**Modification to Eastern Creek Business Hub
Concept Plan (SSD-5175-MOD-5) and Retail Centre Lot 1 (SSD-8858)**

SCHEDULE 1

SSD 5175 MOD 5

SSD 8858

8.8m MEDIUM RIGID VEHICLE
SWEPT PATHS

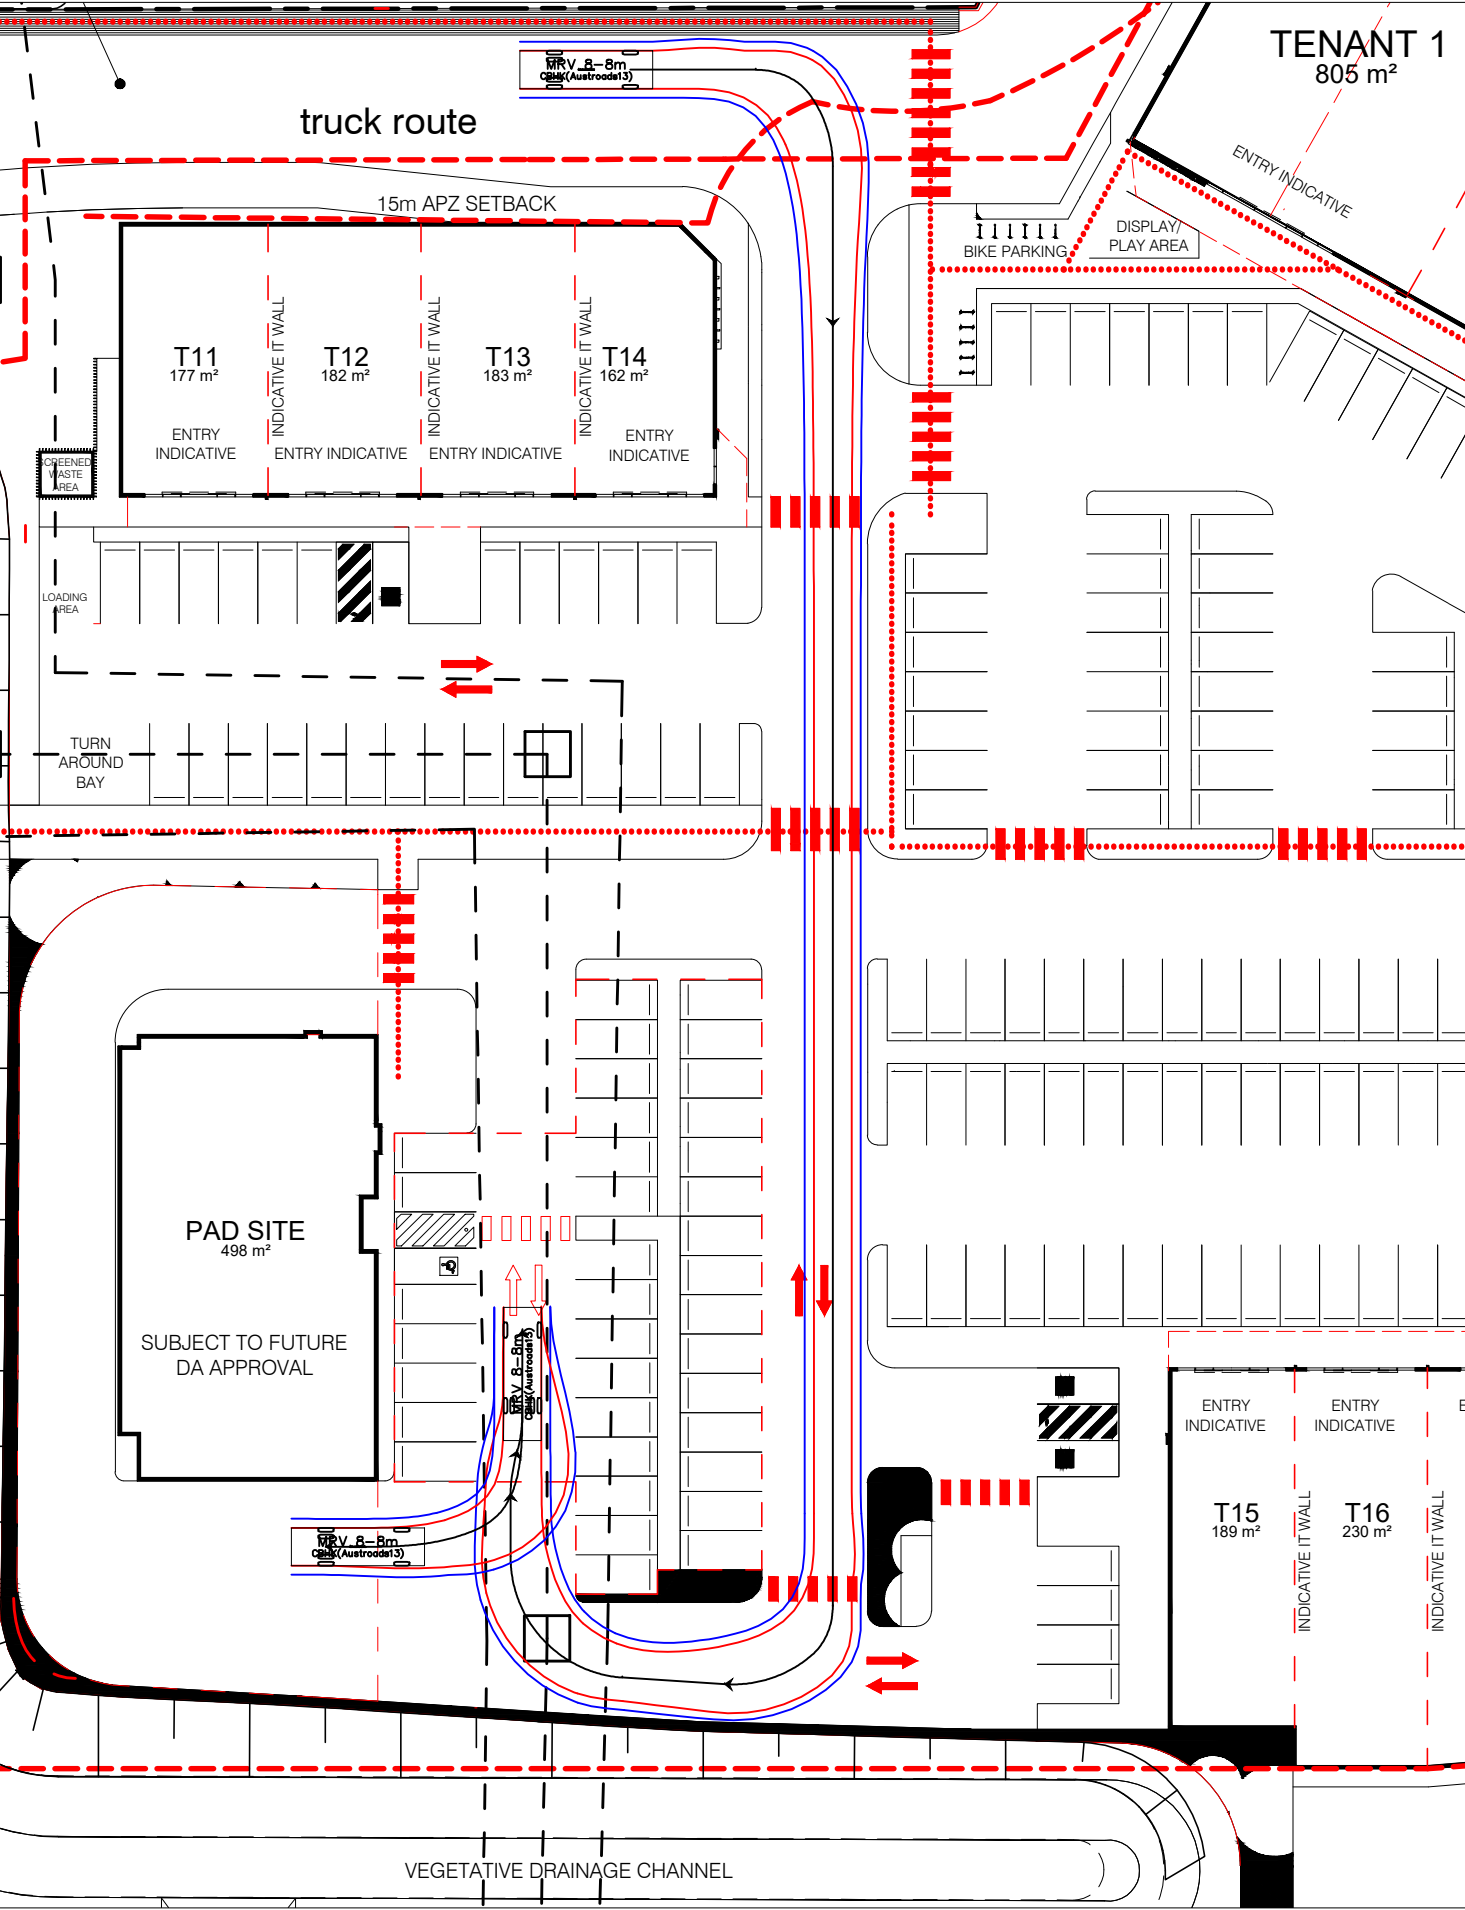
Clarify the arrangements for loading and unloading for buildings 2, 3 and the pad site. In particular:

- the inconsistencies in the RtS and the Operational Management Plan. The RtS notes smaller service vehicles will service buildings 2, 3 and the pad site outside operating hours. However, the proposed delivery hours are 7am to 10pm. In addition, the Operational Management Plan indicates deliveries will be completed by 5pm on Sundays.
- indicate where the smaller service vehicles will park and demonstrate there is sufficient space for these vehicles to manoeuvre within the carpark.

PROPOSED GROUND FLOOR PLAN - SIGNAGE 1 : 500

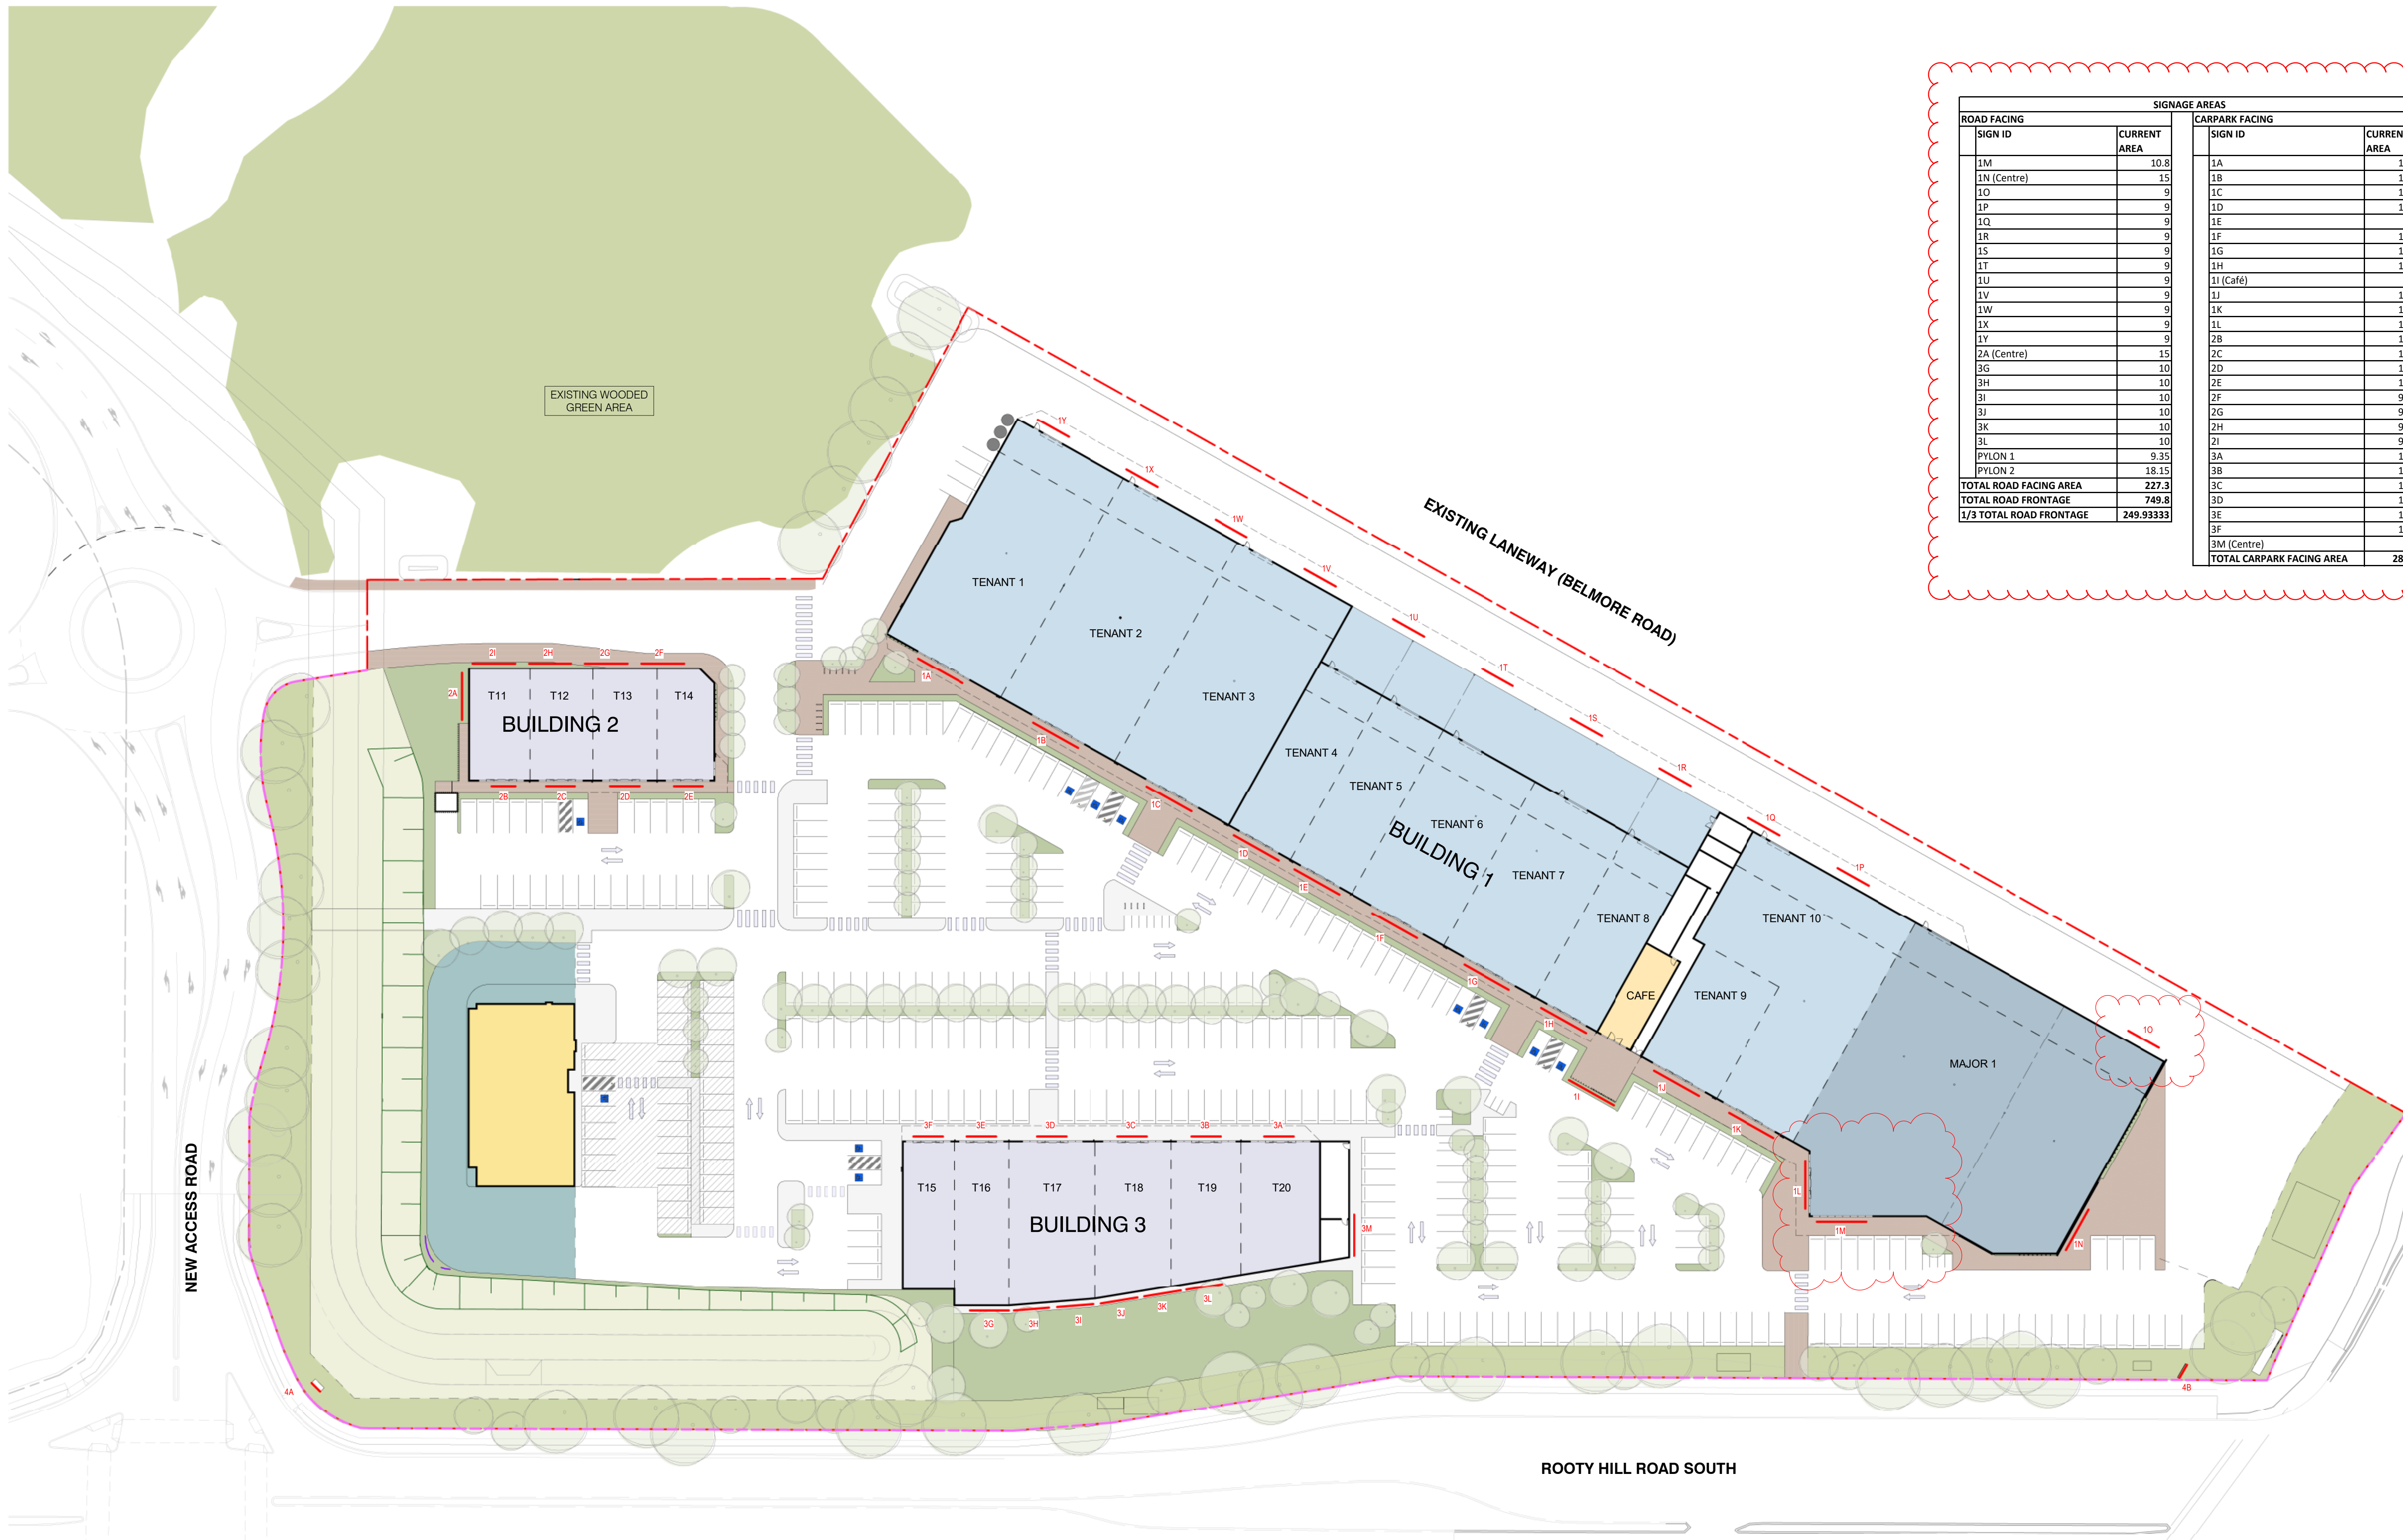
Provide additional justification for the signage zones on the front and rear of the three specialised retail buildings having regard to the private domain signage controls within the Design Guidelines, including:

- advertising signage for the business hub should be kept to a minimum

- for single developments the total permissible signage and advertisements are not to exceed 1 sqm of advertising per 3m of street frontage.

SIGNAGE ELEVATION 11 - SIGNS 3A - 3F 1 : 100

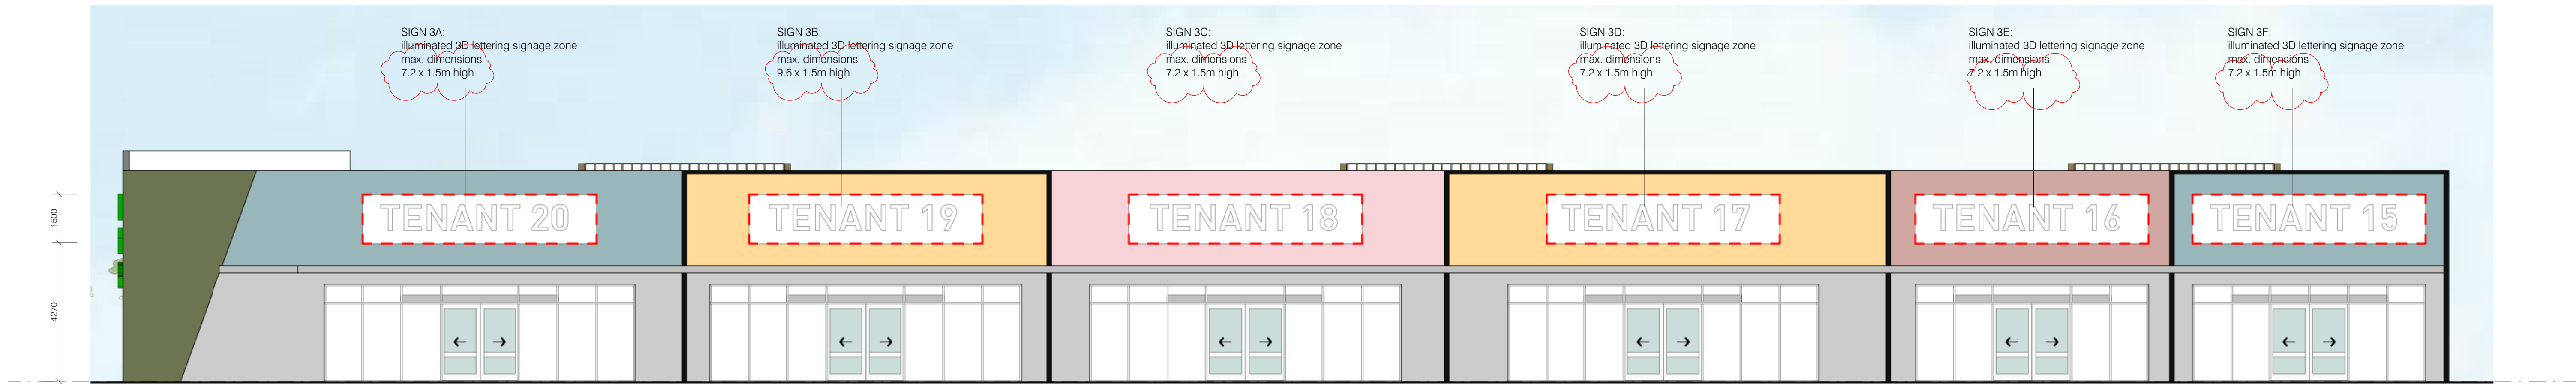
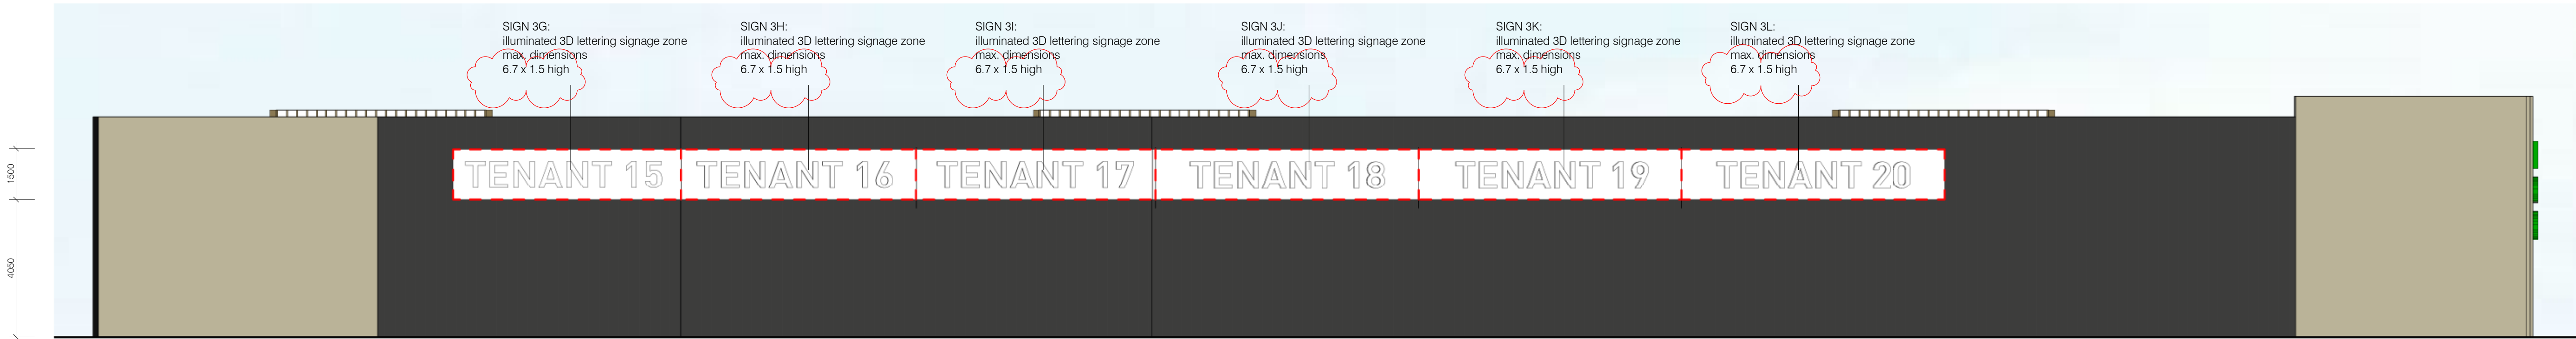
- Provide additional detail of the concrete feature wall proposed to match Stage 1
- Provide additional 3D street views as follows:
 - from within Lot 2, as it is noted the 3D Street view – new access road intersection provides a view of Lot 2, rather than Lot 1
 - a view of Building 3, showing the proposed signage on the RHRS elevation.
